**Byers Gill Solar
EN010139**

8.24 Comments on Deadline 5 Submissions

Deadline 6 - December 2024

Role  
**INITIAL STATUS OR WIP**

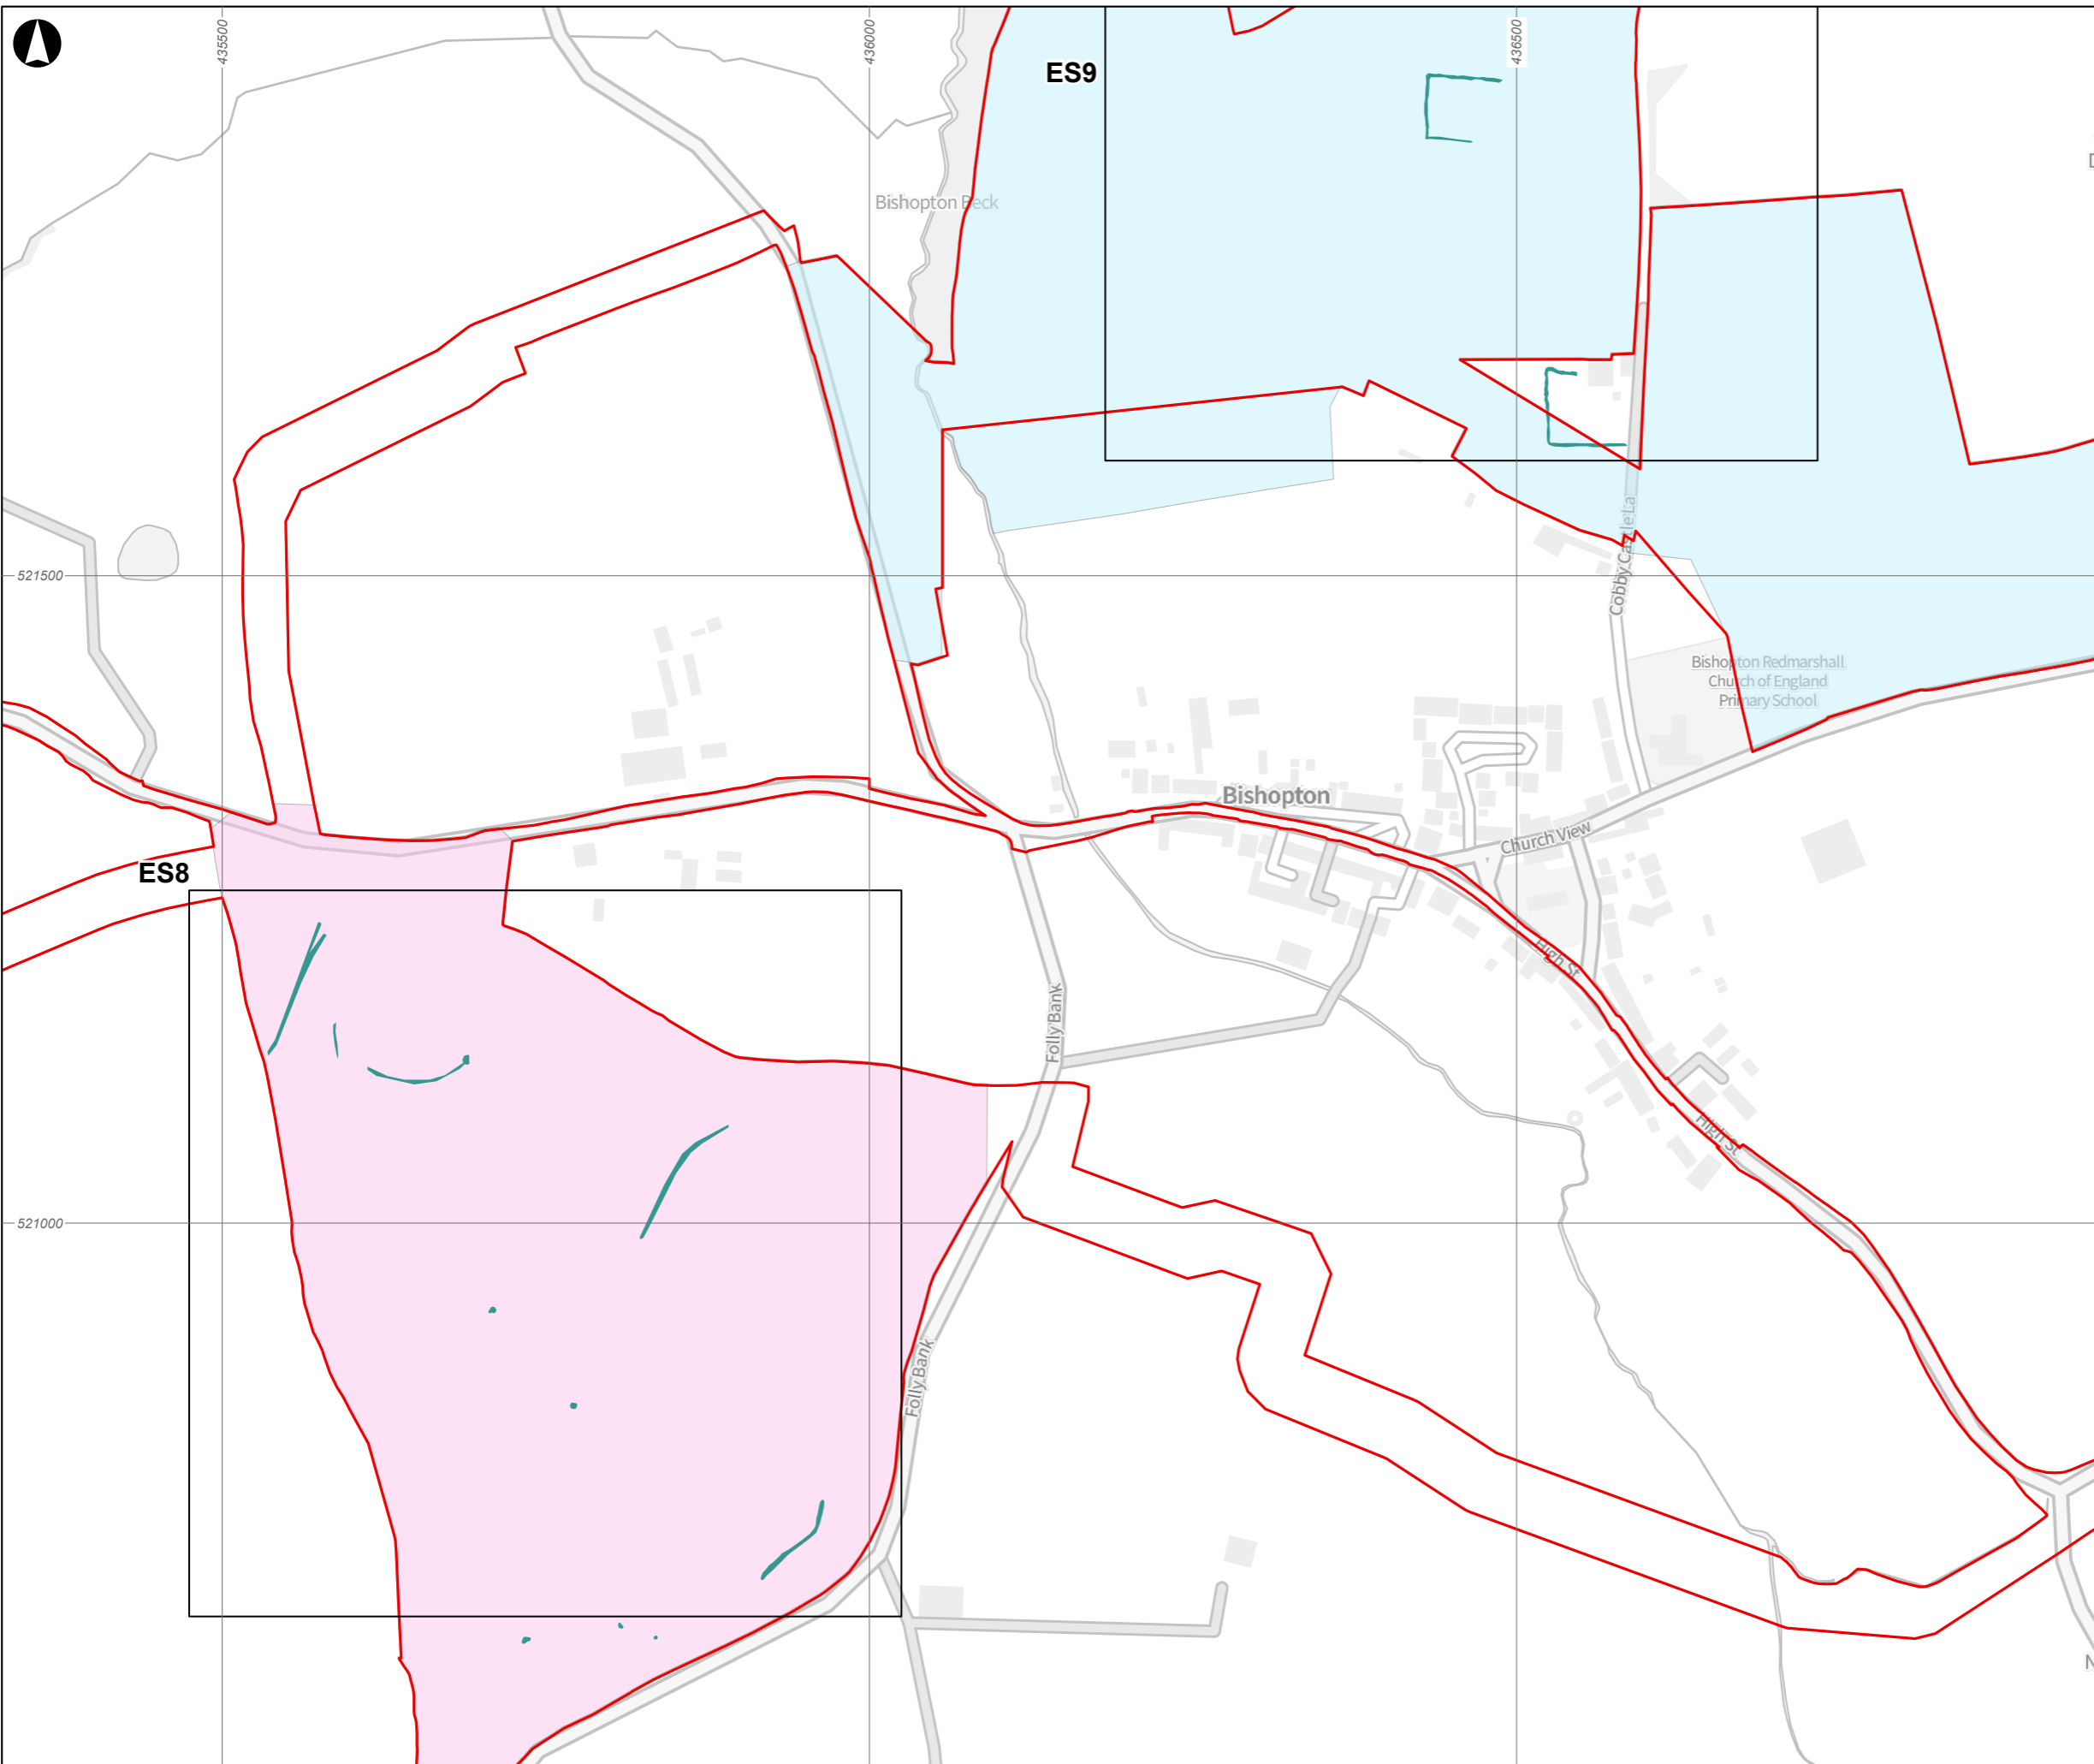
REP4-040	BVAG	<p>BVAG raised the lack of Geophysical Surveys undertaken around the Bishopton Motte and Bailey. The response by the applicant is considered inadequate and does not address why several areas were part of a Geophysical survey for archaeological assessment yet the Motte and Bailey – a Scheduled Monument and the highest grade heritage asset within the DCO area - was excluded.</p> <p>BVAG consider that Historic England's comments on settings relate to above ground assets. The Scheduled Monument which is an 11th century fortress has obvious potential underground assets. It was in fact one of a handful of Motte and Bailey's within the UK studied for potential earlier origins. The proposed construction of a major infrastructure cable immediately adjacent has the potential to harm underground assets. No reasonable explanation was given for its exclusion in the archaeological geophysical survey, and BVAG consider this</p>	<p>The Applicant considers this matter was discussed and answered sufficiently as ISH2 and refers to the summary on page 23 of REP4-010, which confirms the surveys were not undertaken at this location as it is a potential cable route and not a panel area. The provision of further archaeological investigation in this location prior to commencement is secured via Requirement 17 of the draft DCO. The Applicant notes the comments of BVAG regarding Historic England, the national statutory advisor for the historic environment.</p> <p>The Applicant and Historic England are in agreement regarding the assessment of the effects of the Proposed Development on the Scheduled Monument, as set out in the signed SoCG between the parties (Document Reference 8.4.5, Revision 2).</p>

Examination Library Reference	Interested Party	Summary	RWE Response
		<p>should be remedied before consent is granted. A post consent precautionary approach as proposed by the applicant at the Hearing is inadequate for such a high grade asset of this nature.</p> <p>BVAG are undertaking further research into this site and will be reporting in due course.</p>
